**From:** [Kelly Bacon \(CD\)](#)  
**To:** [Val](#)  
**Cc:** [Dan Carlson](#); [Arden Thomas](#); [Holly Erdman](#); [Tristen Lamb](#); [Jeremy Johnston](#); [Stephanie Moore](#); [Sam](#)  
**Subject:** RE: SPF-21-00002 Zipperer - Comments and RFI Compliance  
**Date:** Wednesday, July 21, 2021 4:38:21 PM  
**Attachments:** [image001.png](#)

**Subject:** SPF-21-00002 Zipperer - Comments and RFI Compliance

**ZIPPERER SHORT PLAT, SP-20-00005
 SPF-21-00002**

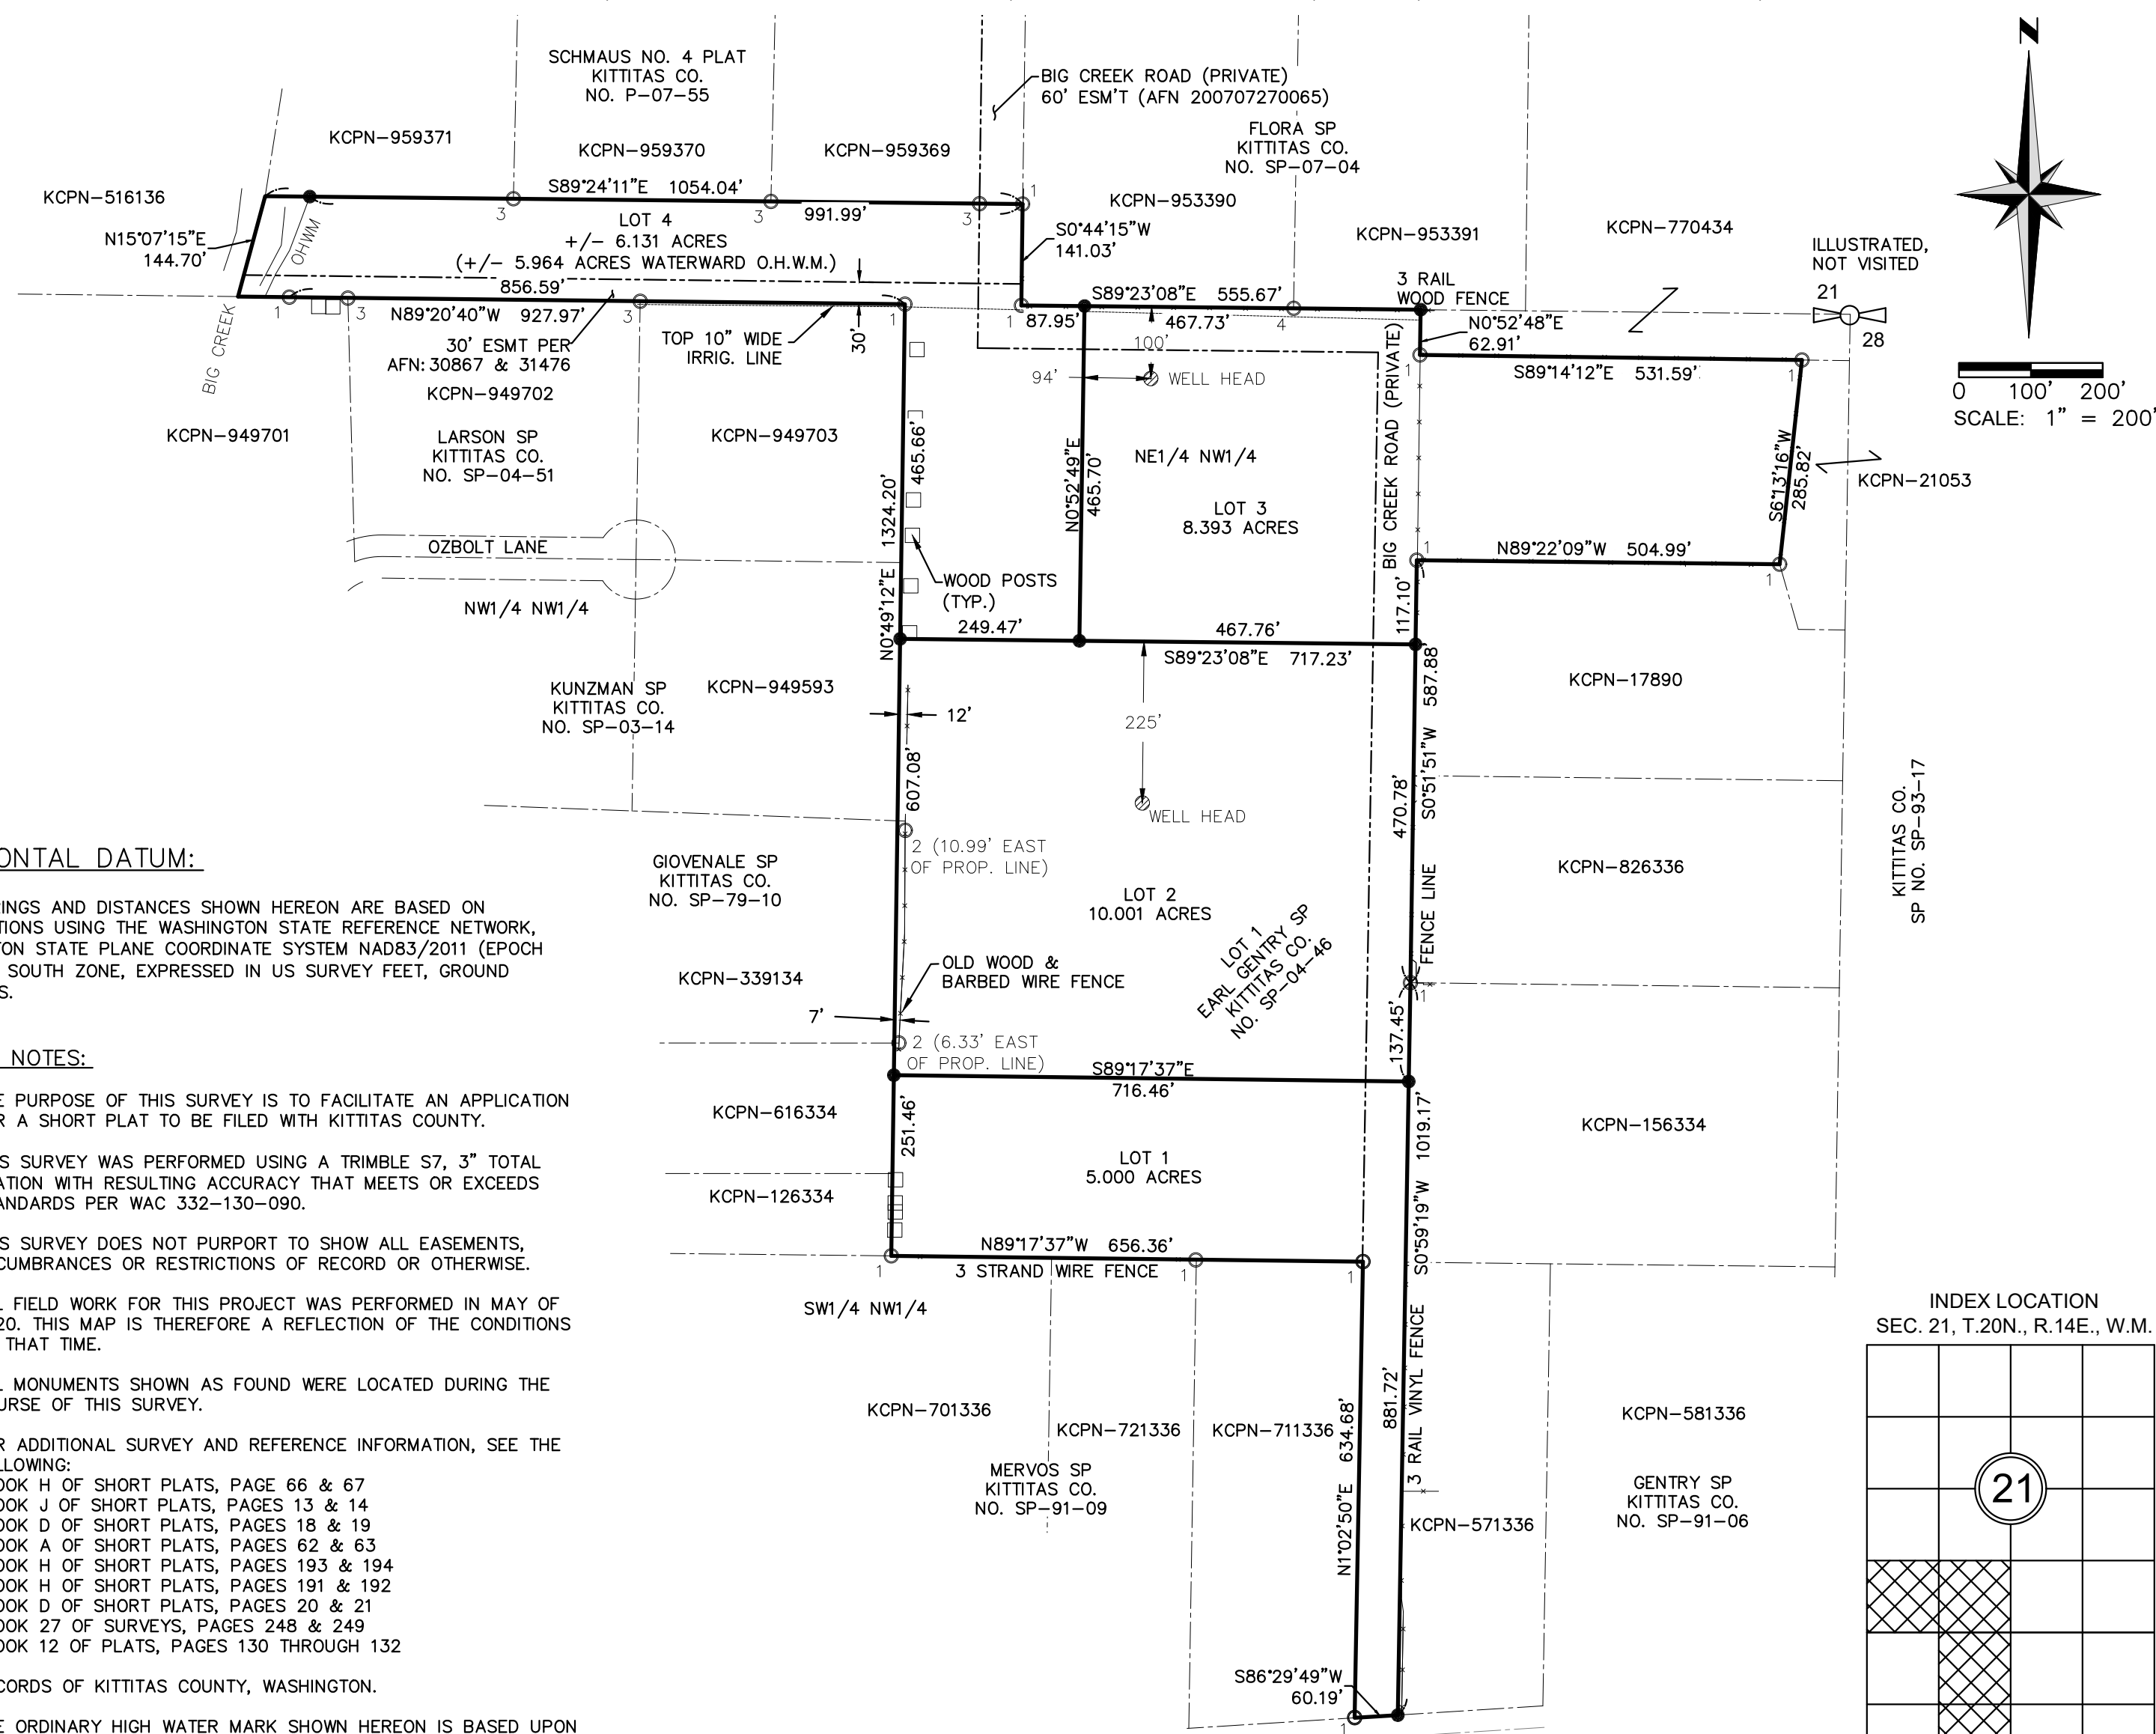
Please also note, the proposed Lot 2 North boundary line is the only interior boundary requested to be revised by Public Health. By moving that lot line further north, it automatically shortens the dividing line between Lots 3 and 4 - nothing can be done to prevent that while meeting the Public Health condition/requirement. Public Health is requiring that line to be moved further north and nowhere in the preliminary conditions of approval does it state that line can *only* be moved by 50'. In fact, CDS omitted this Public Health condition of approval from the Finding of Fact, Decision and Conditions of Approval altogether (attached for your reference). This condition was only cited by CDS in a letter dated July 1, 2021 with the Subject: Zipperer Short Plat Final (SPF-21-00002) – Staff Review and Request for Additional Information after the Final Short Plat Application was submitted (attached for your reference).

The Zipperer's are proposing to move the exact lot line that Public Health is requiring them to move and all codes, standards, requirements, and conditions are still being met with this MINOR adjustment to the North interior boundary line of proposed Lot 2. Attached is a map of the preliminary short plat layout showing the North interior boundary line of proposed Lot 2 too close to the well head AND a map of the final short plat layout with the revised North interior boundary line of proposed Lot 2 meeting the condition as set forth by Public Health. We do not agree that this required interior lot line revision constitutes a re-application to amend the short plat as it is a condition that needs to be met for a short plat currently under review.

Thank you for the requested information. During initial review of the amended Final Short Plat survey, CDS notes substantial changes taking place to lot lines and acreage associated with three of the four parcels. CDS previously agreed to allow minor changes to the lot lines in order to meet the 50' well setbacks. Substantial changes as proposed would require an amendment to the Approved Preliminary Short Plat.

CDS is requesting an updated site map meeting the previously approved preliminary short plat with the acceptance of a few lot lines needing adjustment to meet the 50' minimum well setback or the

applicant could choose to move forward with an amendment.

In subsequent conversation with the Planning Official, Jeremy Johnston, CDS staff agrees that although the lot sizes are changing significantly, substantial conformance is met. We have requested final review from both Public Works and Public Health. Once we have received final approval from each department, we will request the final mylars and route for final signatures.
